**Re: Panda Express at 2040 Gibson Blvd SE (Lot C-2 Lovelace Heights Addition.)
Erosion and Sediment Control Plan
Engineer's Stamp date 11/19/2024 (M15E021F) SWQ-2025-00012**

Based on the information in your submittal received on 2/21/25, the above-referenced ESC Plan can't be approved until the following comments are addressed.

C06.1

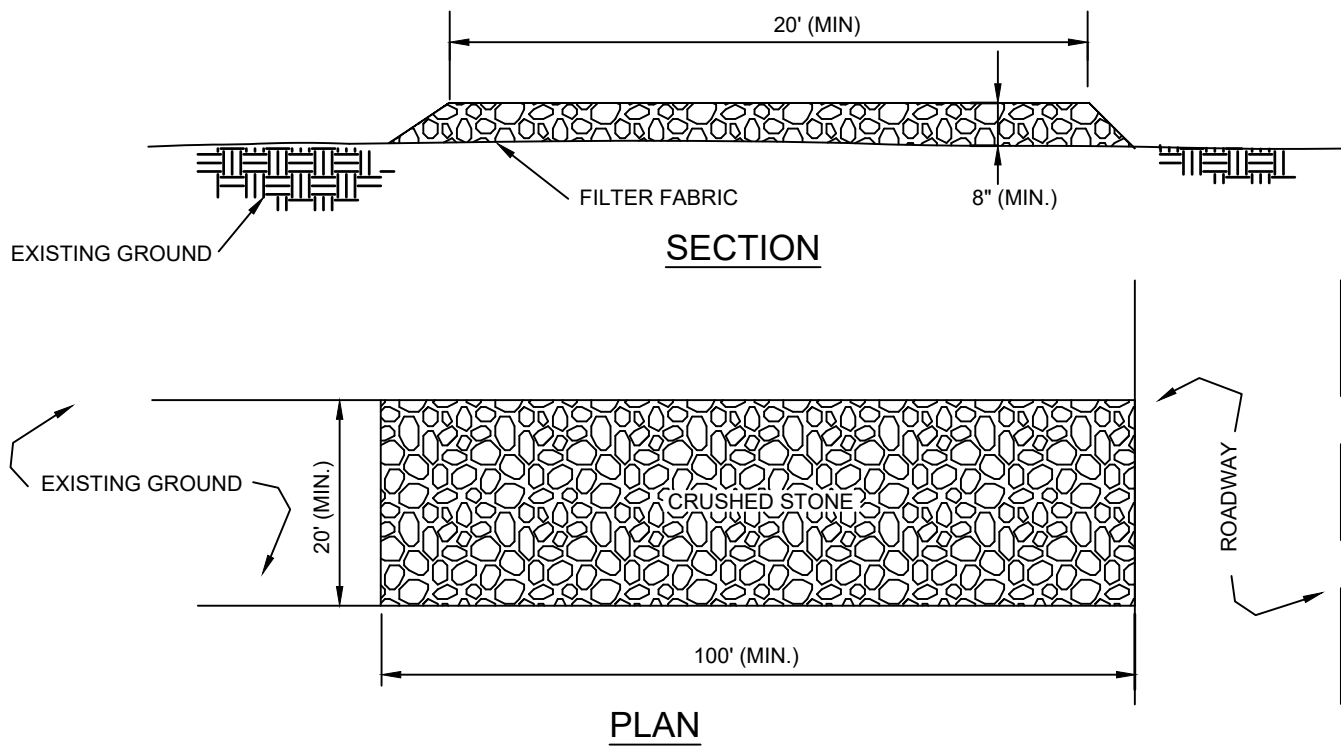
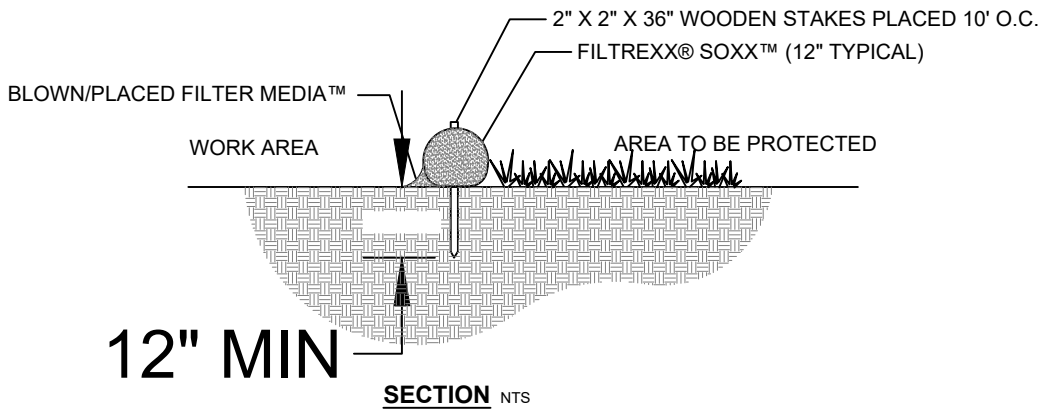
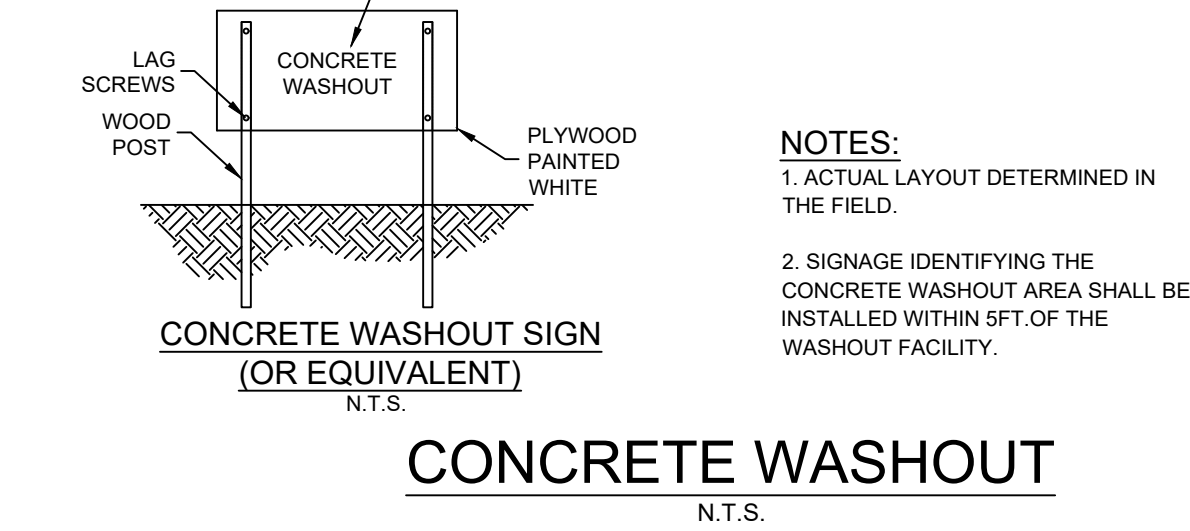
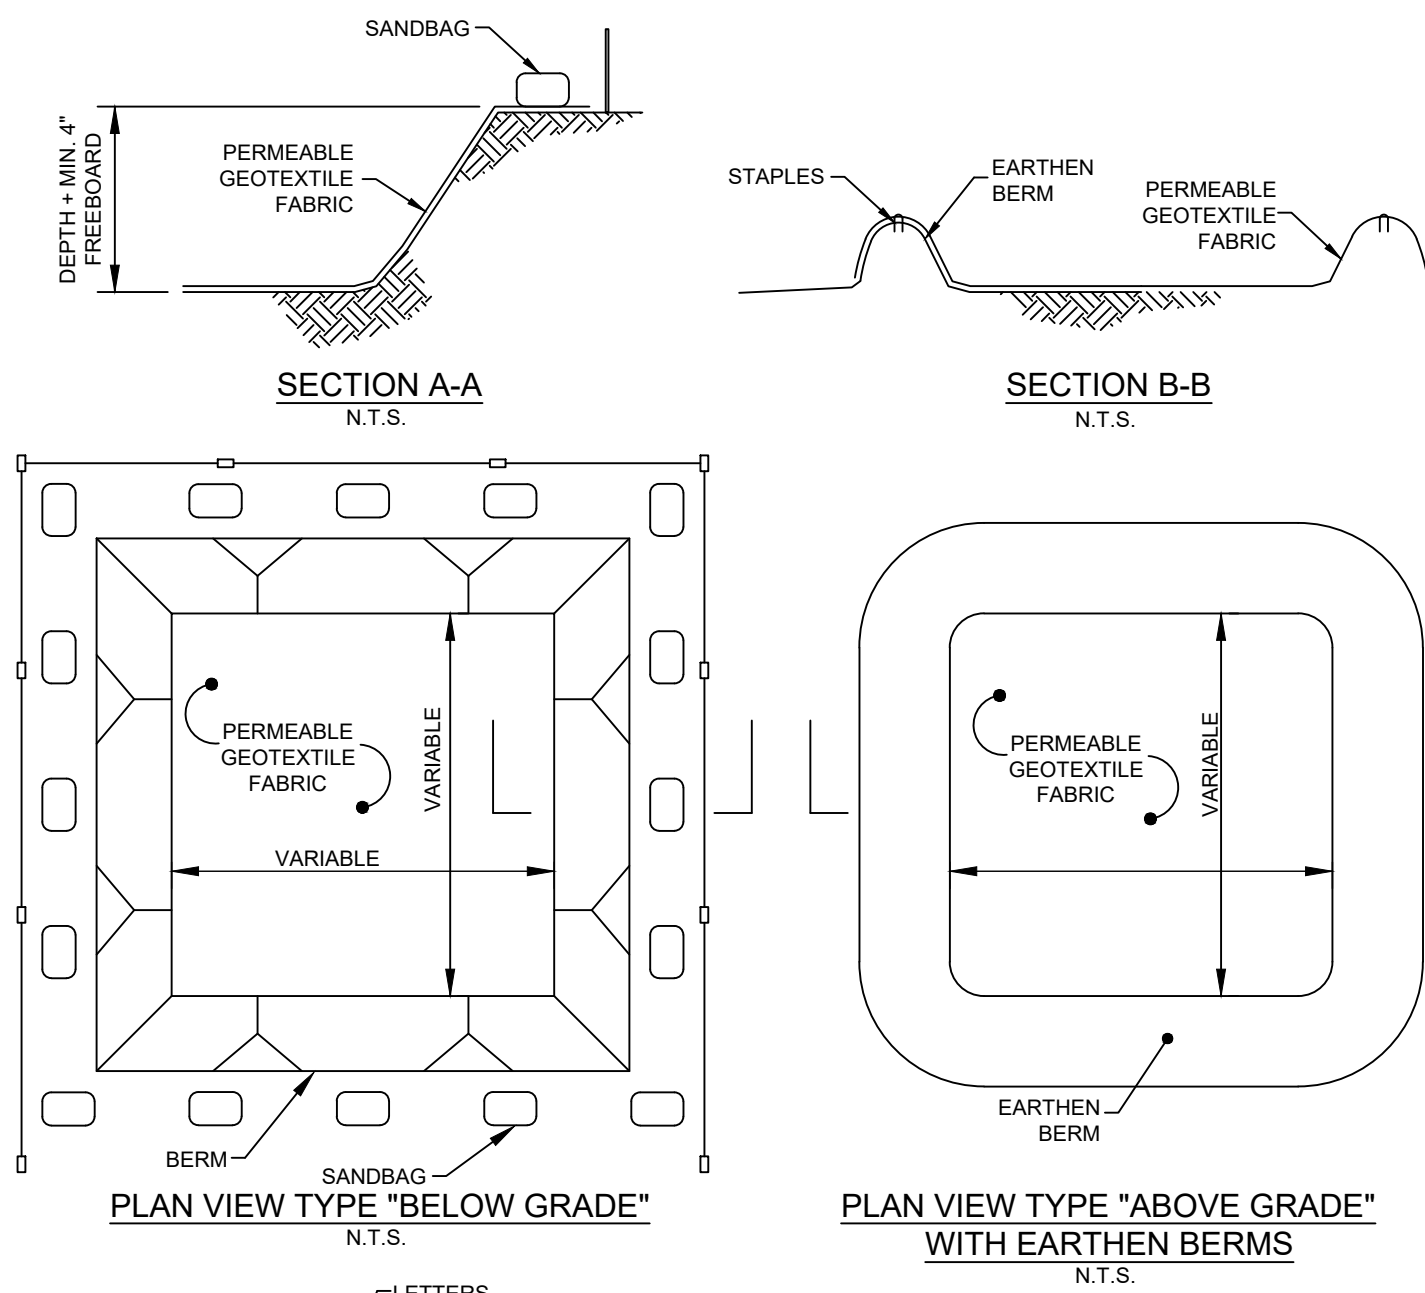
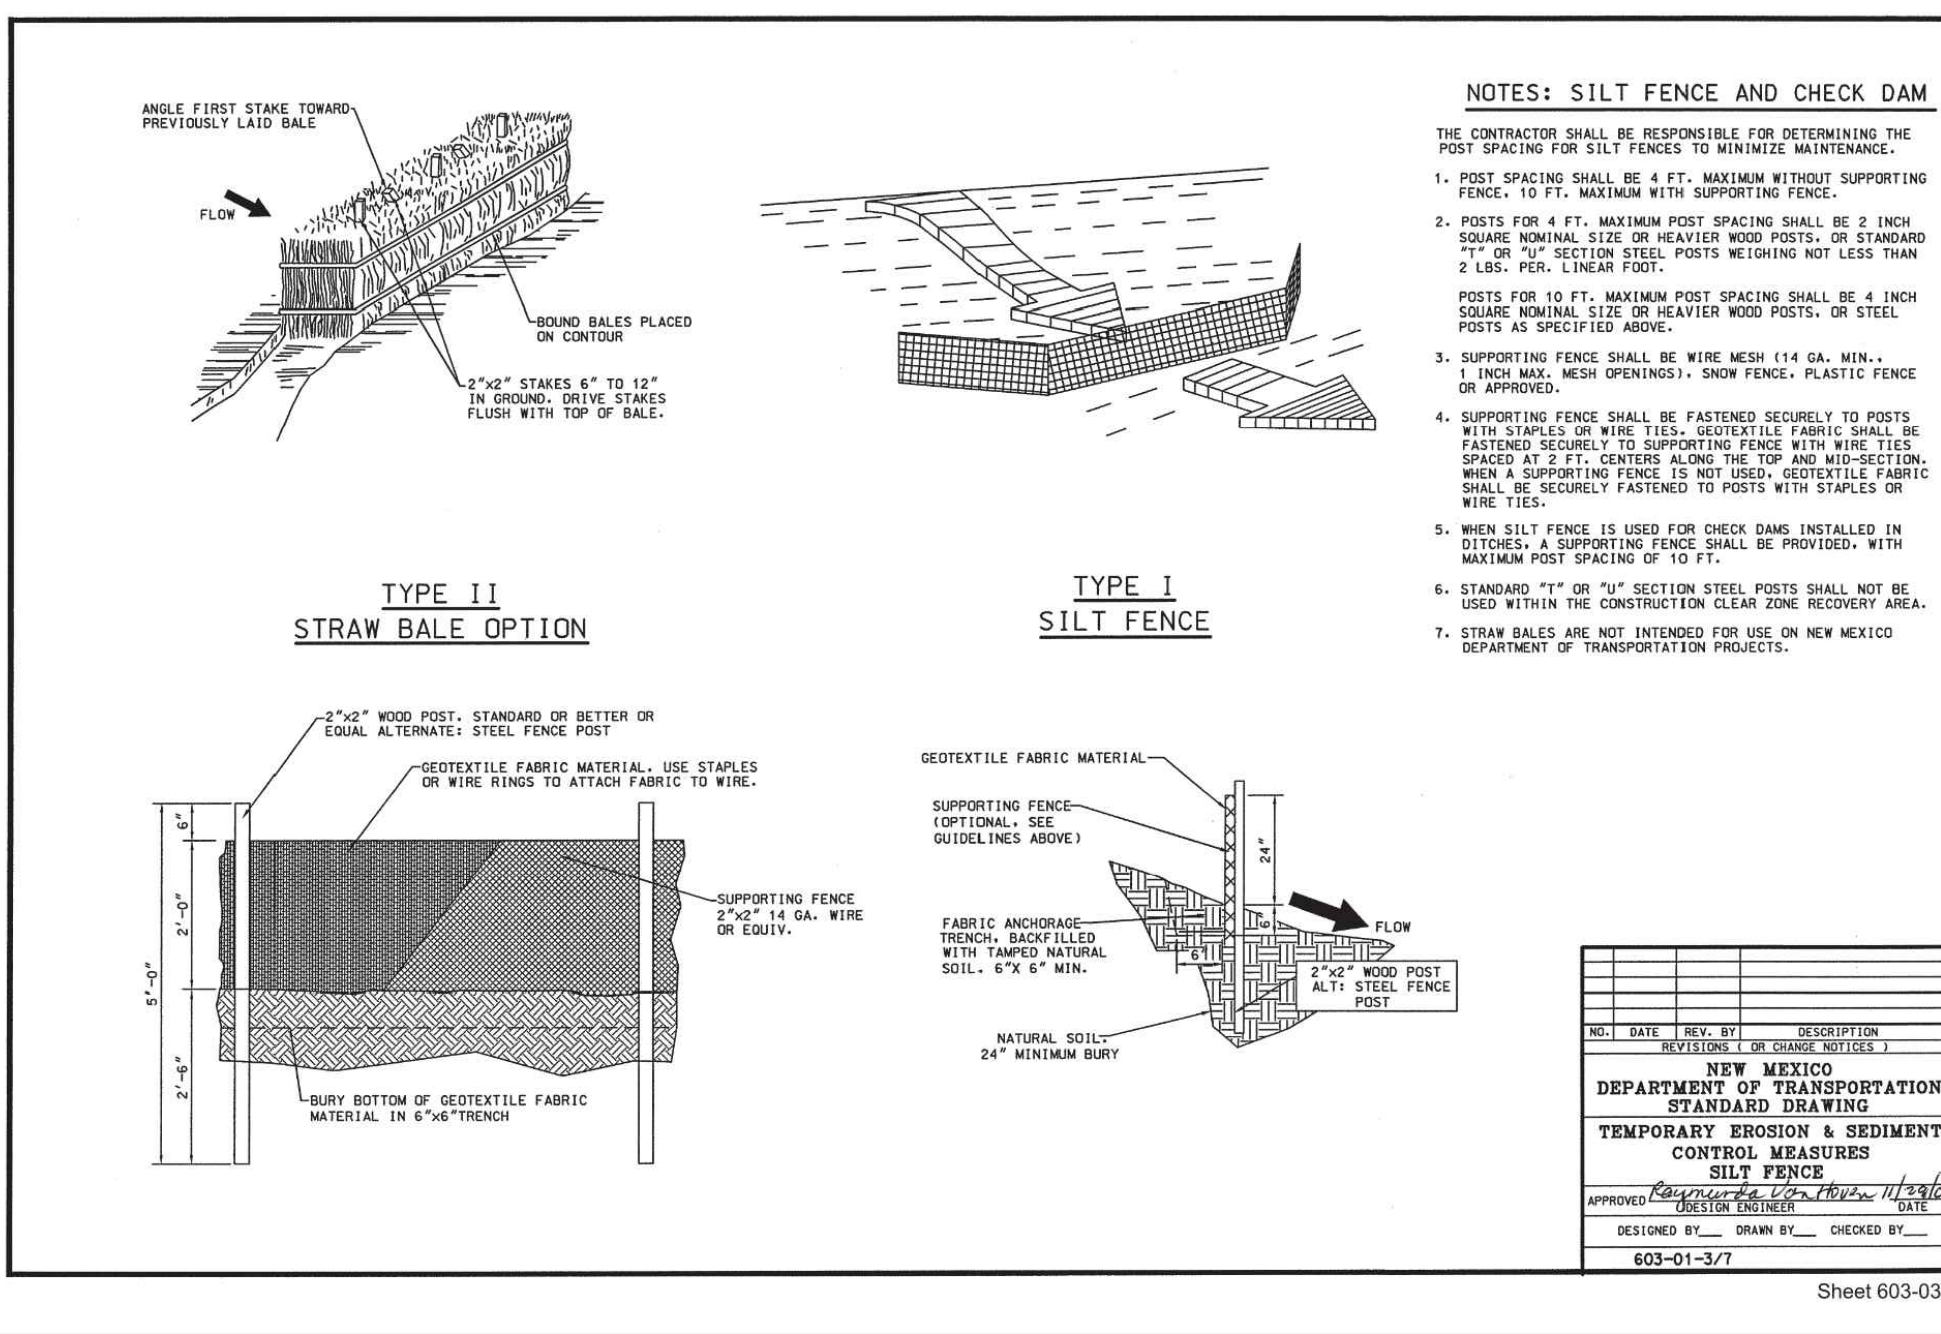
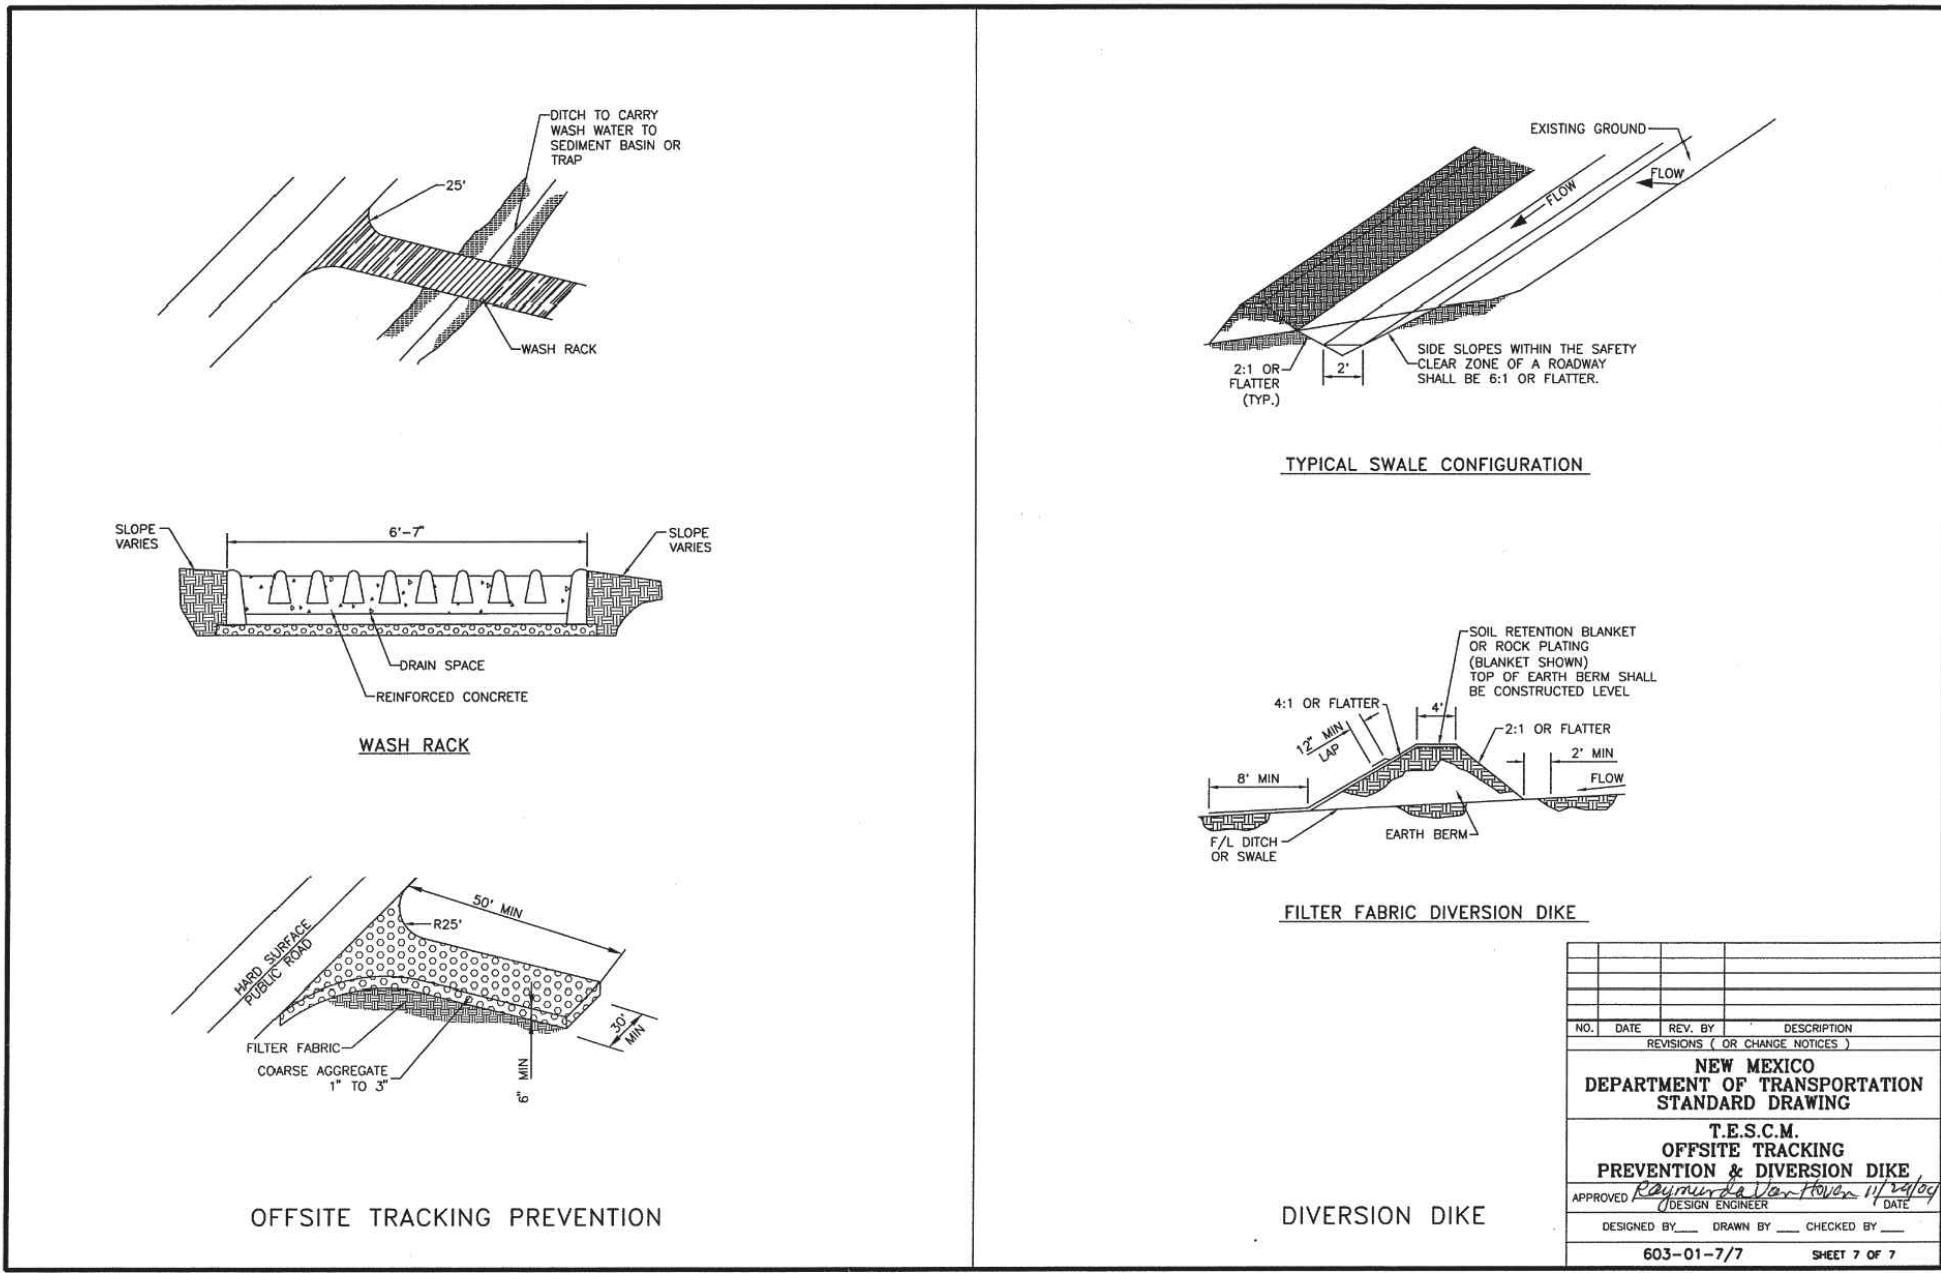
7. Construction details and specifications are missing from the ESC Plan for most of the stormwater controls, including but not limited to Stockpile Management, Silt Fence, Diversion Berms, and Sediment Traps. NMDOT has details for most of these BMPs at [NMDOT NPDES Manual Rev 4 2023](#) in Appendix A. Mulch socks don't seem appropriate, but if used, they should be staked per NMDOT detail instead of weighted down.
